Monument Junction West Filing No. 1
Construction Documents Review (Streets, Storm Sewer and Final Drainage Report
Review) - Submittal 2

Date:	07/25/2022	Jacobs Engineering Group Inc.
Project no:	A.PN.CI.067	6312 S. Fiddlers Green Circle
Attention:	Debbie Flynn, Planner II	Suite 300N
Company:	Town of Monument:	Greenwood Village, CO 80111
Prepared by:	Mark Kitzmiller	United States
		T +1.720.286.2000
		www.jacobs.com

1. "Monument Junction West Filing No. 1 Construction Plan Set," by Classic Consulting, dated June 20, 2022.
2. "Final Drainage Report for Monument Junction West Filing No. 1," by Classic Consulting, dated July 2022.
3. CCES Responses to Submittal 1 review memo. **Note: Per e-mail attached, Jacobs did not have any comments on storm or pond plans.**

CURB NOTE:
ALL CURB TO BE CONSTRUCTED FOR THIS PROJECT SHALL BE TYPE 1.

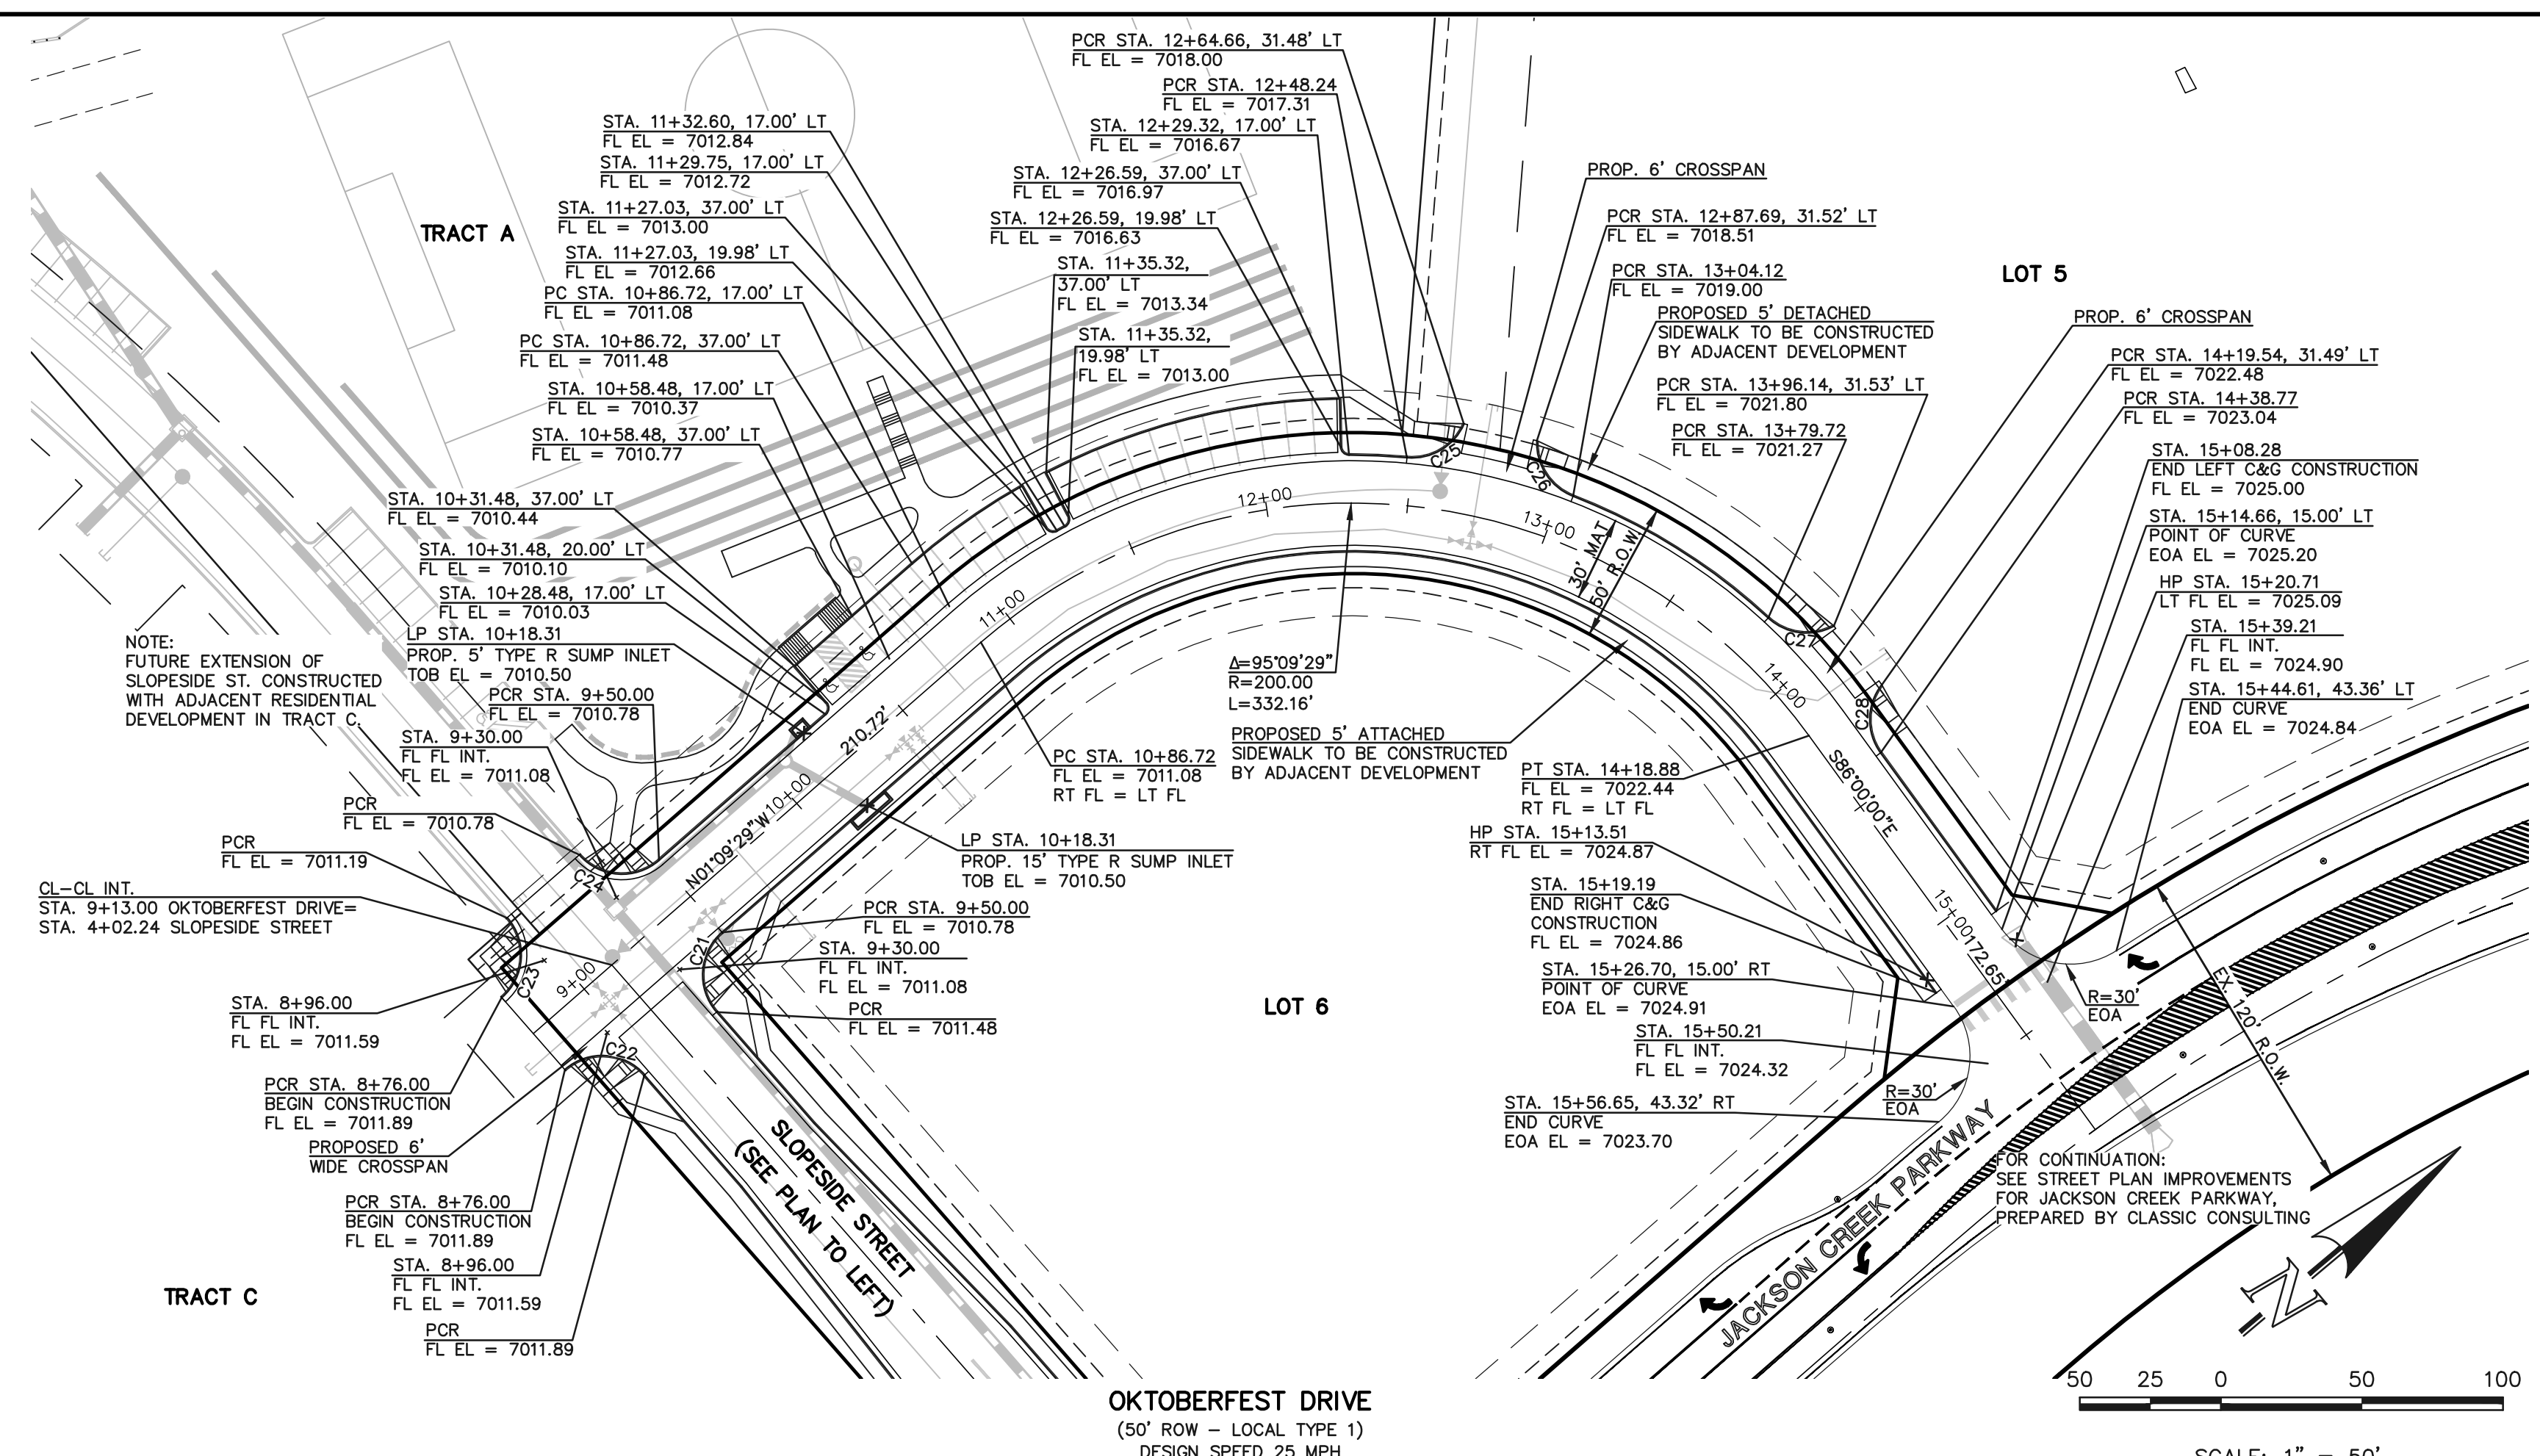
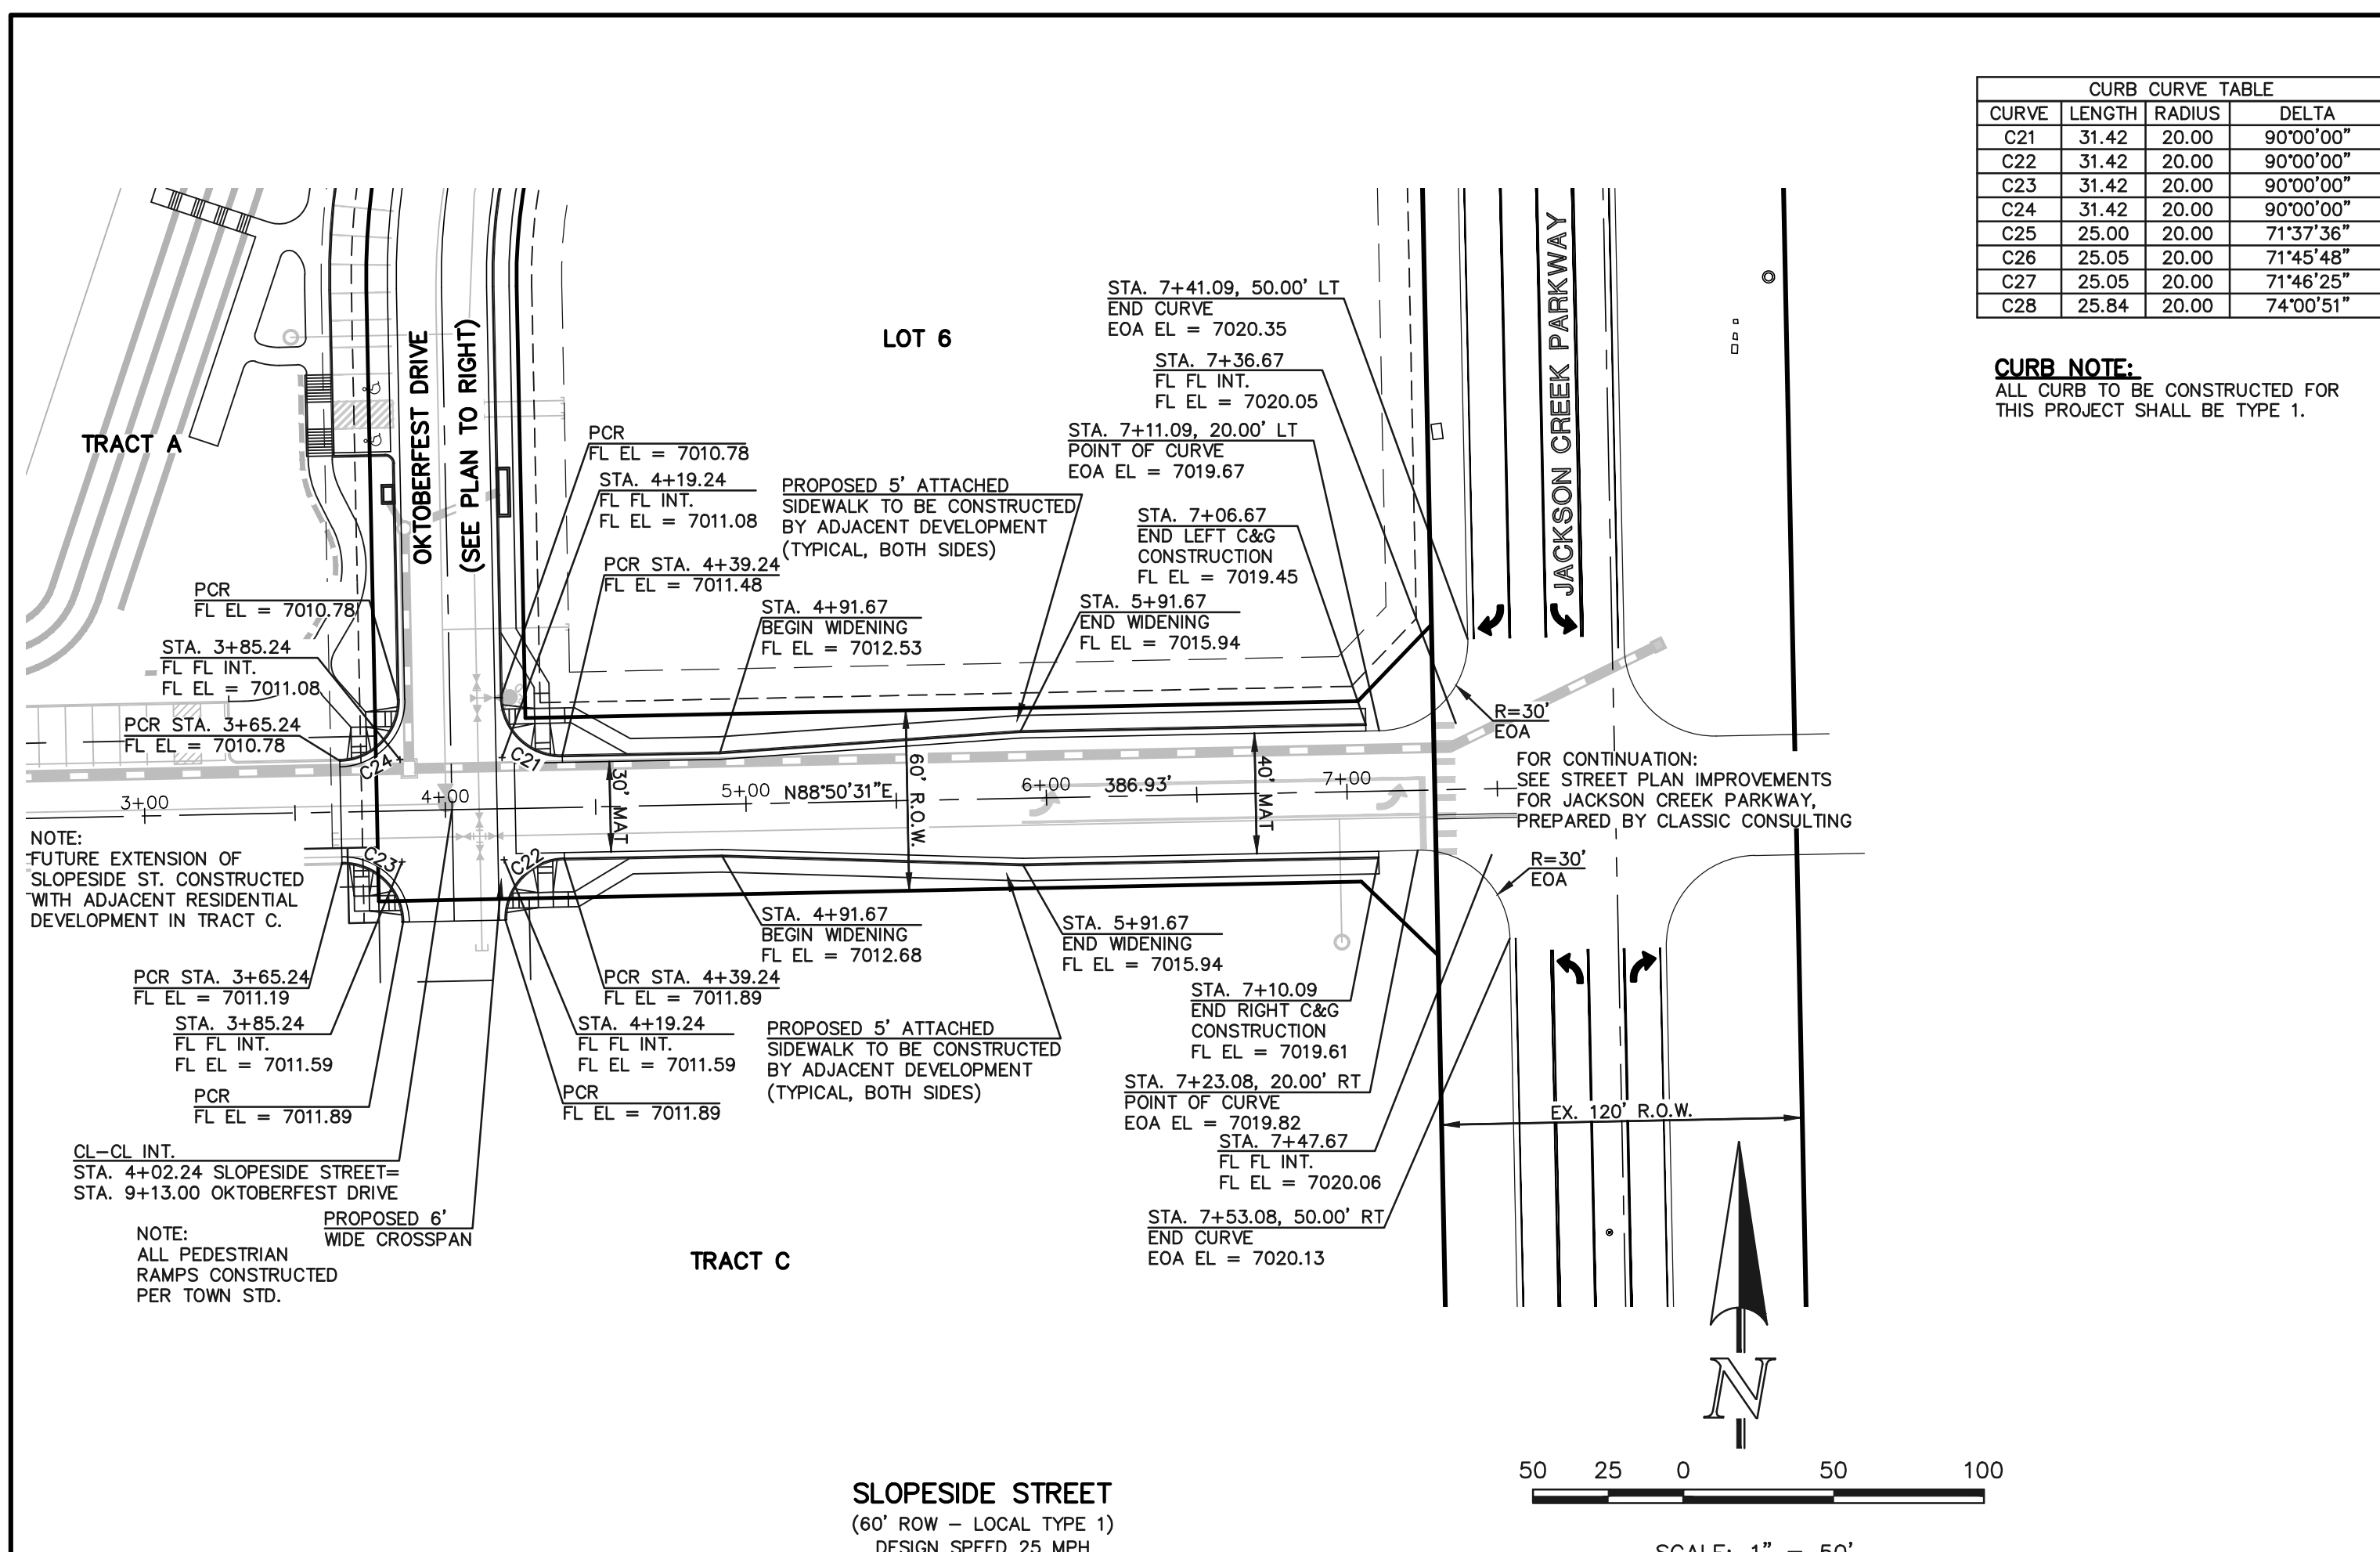
1. Curb return radii C12 and C13 do not meet the minimum curb return radius requirements. **Not addressed. Curb return radii requirements are listed in Table 5.2 of Appendix A of the Town of Monument Roadway Design and Technical Criteria. A waiver would be necessary to reduce curb returns radii from 30 feet to 20 feet.** Waiver for curb returns now provided

2. K value for vertical curve at station 15+09.01 for Oktoberfest Drive right flowline does not meet the minimum requirements. **Not addressed. Intersection is currently stop condition but could have a signal in the future; therefore, K value needs to meet design speed of the road.** This design follows the CDOT approach road std. M-203-1 and provides for a 20 mph design speed at the int. This int. is planned to be a RI/RO only and NO signal planned.

3. K value for vertical curve at station 15+16.21 for Oktoberfest Drive left flowline does not meet the minimum requirements. **Not addressed. Intersection is currently stop condition but could have a signal in the future; therefore, K value needs to meet design speed of the road.**

This design follows the CDOT approach road std. M-203-1 and provides for a 20 mph design speed at the int. This int. is planned to be a RI/RO only and NO signal planned.
